Project Name: CONDOMINIUM CONVERSION
Address: 130 EASTERN PROMENADE
Applicant: FISH HOUSE REALTY, LLC
Planner: SHUKRIA WIAR

Project ID: 2011-258
CBL: 003-C-001

On June 30, 2011, the Portland Planning Authority approved a Level II Site Plan Application for renovation and conversion of the existing three story residential structure from eleven (11) apartments into a three (3) unit condominium located at 130 Eastern Promenade. The project will include demolition of an existing one story structure on the rear and side of the main building, and the construction of an addition to the south side of the building and of an open-air attached carport for three compact cars. Additional site improvements include relocating the existing driveway, additional surface parking behind the building, and landscaping improvements. The approval was based upon the applicant's submittal, including but not limited to the site survey by Robert Greenlaw of Ocean Park Land Surveying, LLC, and the approved site plan prepared by Carroll Associates and dated 06.21.2011, with the following waivers and conditions as presented below:

Drawing Title: SITE LAYOUT & MATERIALS PLAN

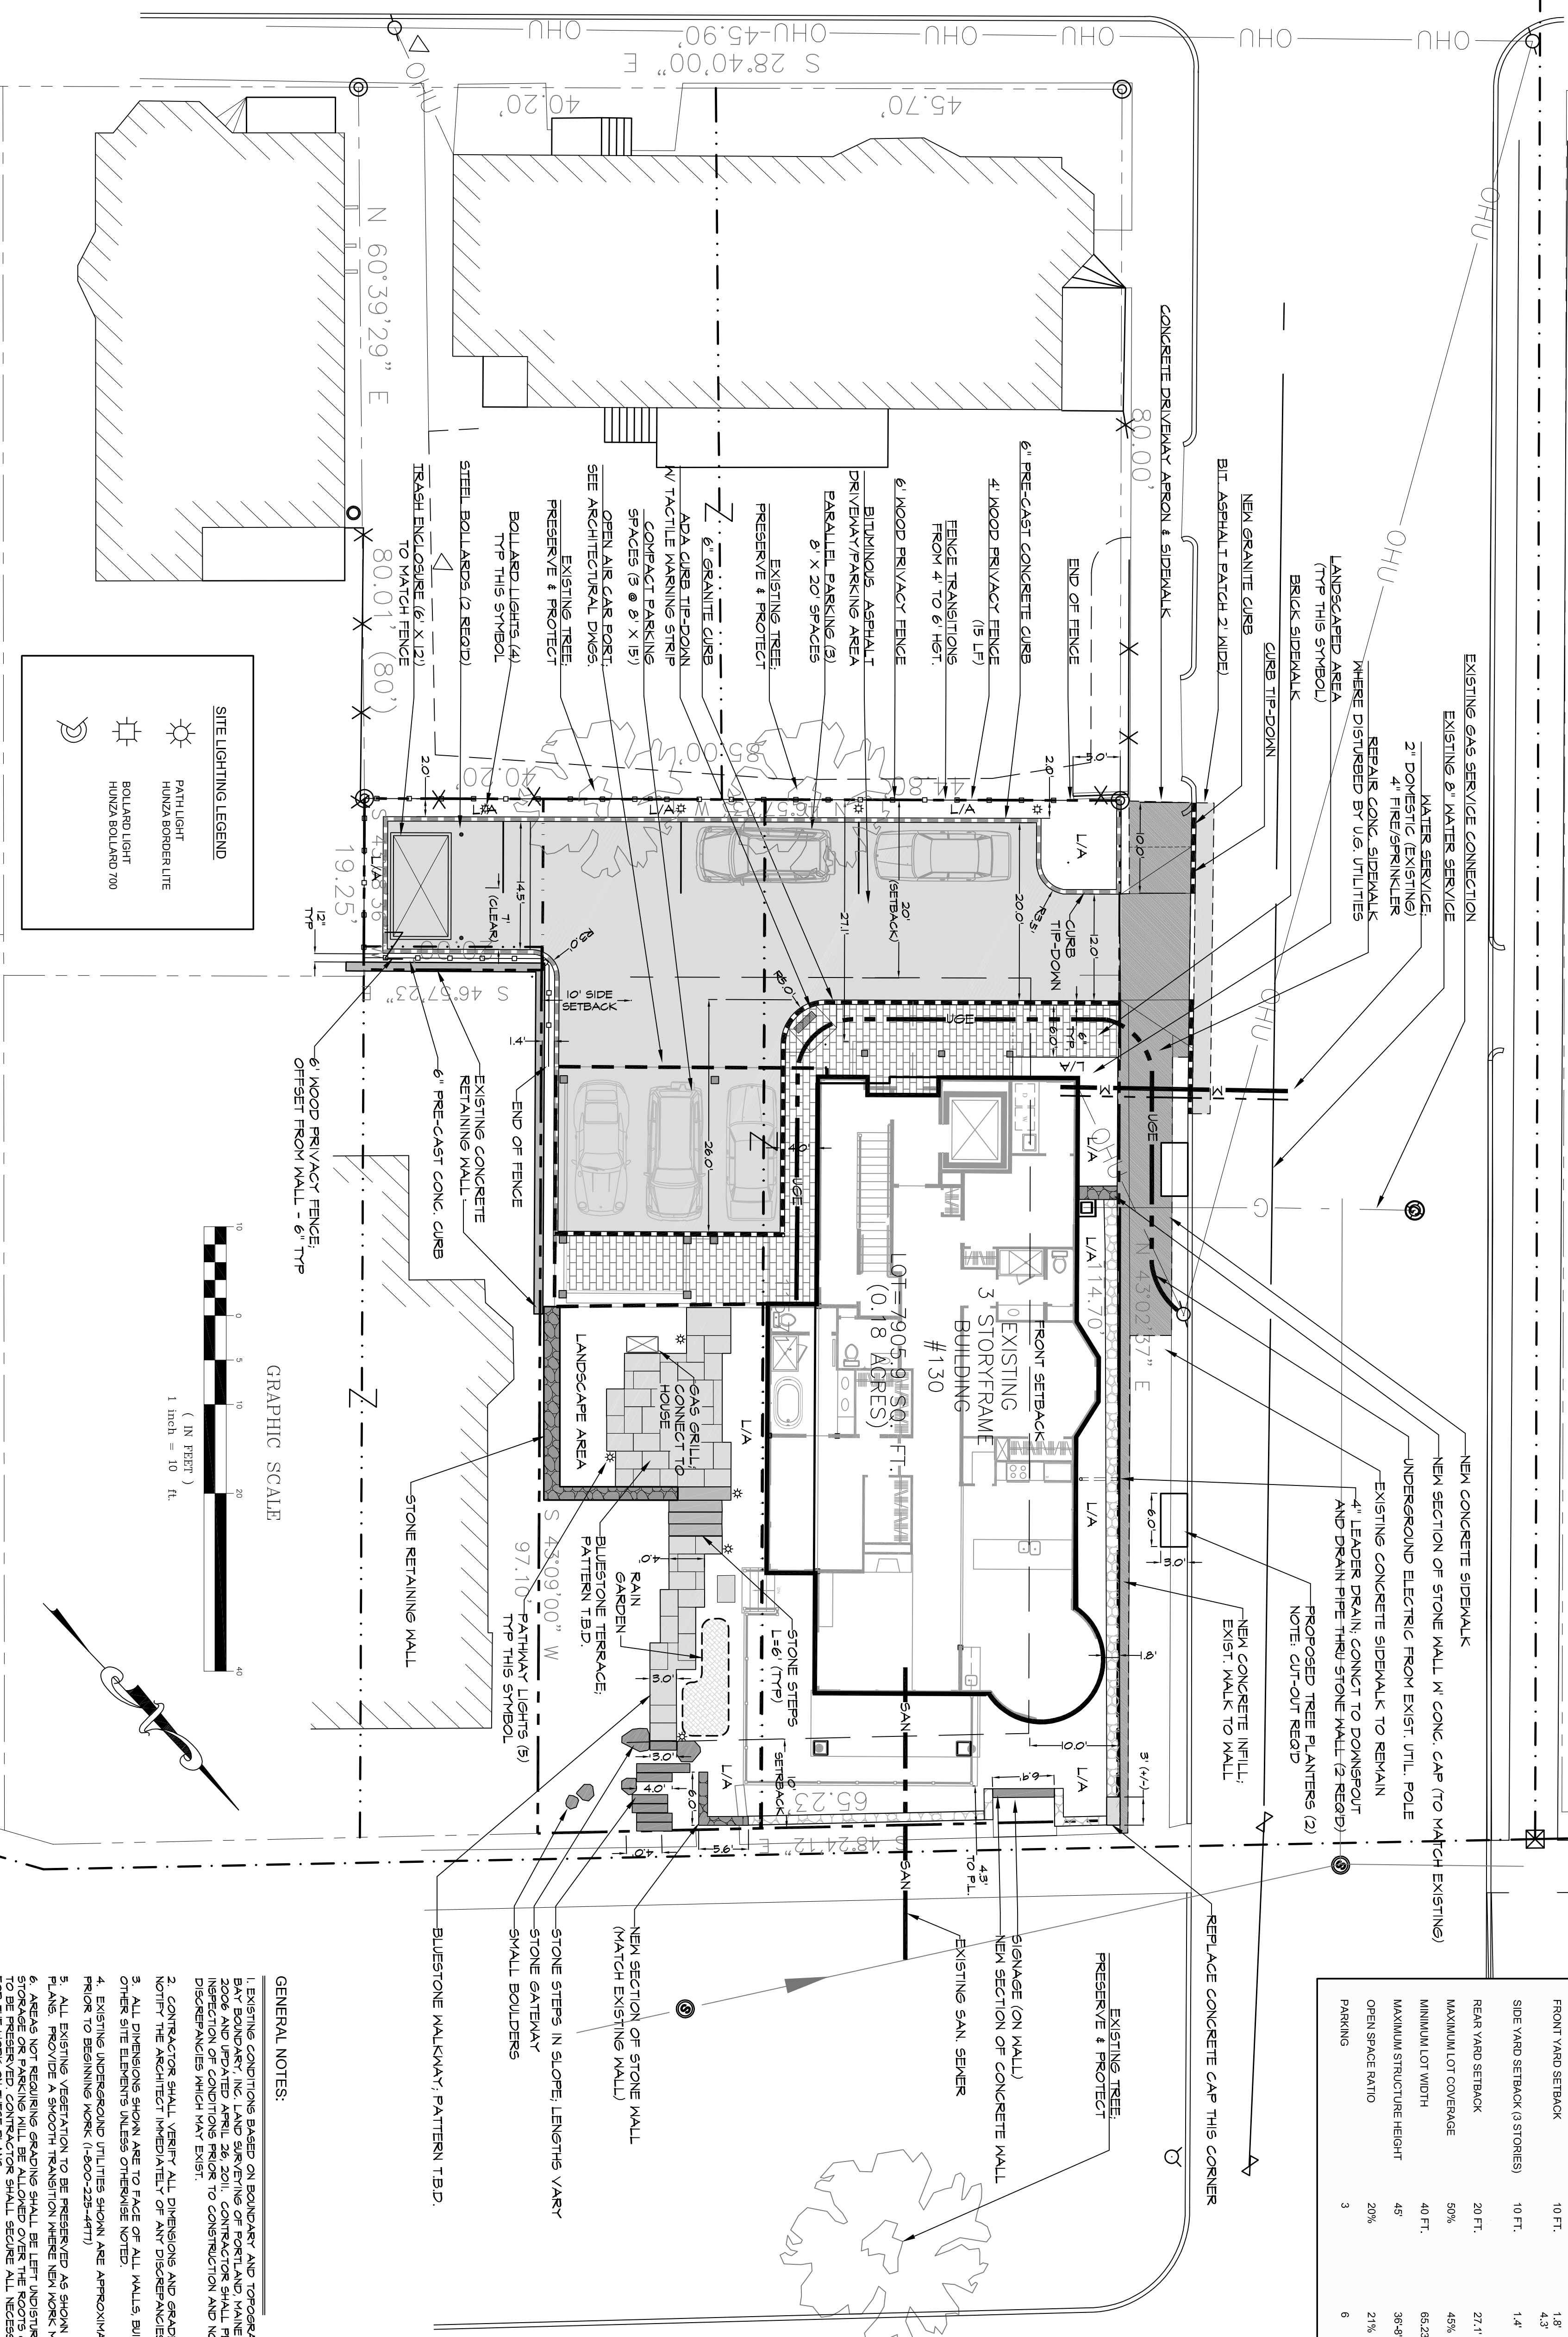
- a. To allow the two parallel parking spaces to be 8' x 20' along the driveway instead of standard parking size of 9' x 18'.
- b. To allow compact parking spaces under the canopy.
- c. To allow a reduced aisle widths of 12' and 23' instead of the required width of 24' for two-way traffic.

3. That the parking space near the trash enclosure shall be eliminated for improved on-site circulation and egress movements.
4. The proposed condensing units and any roof top mechanicals shall be screened by an architectural structure wall and shall have noise suppression mechanism. The applicant shall provide documentation of the projected noise levels at the property line and any mitigation measures prior to building permit issuance.
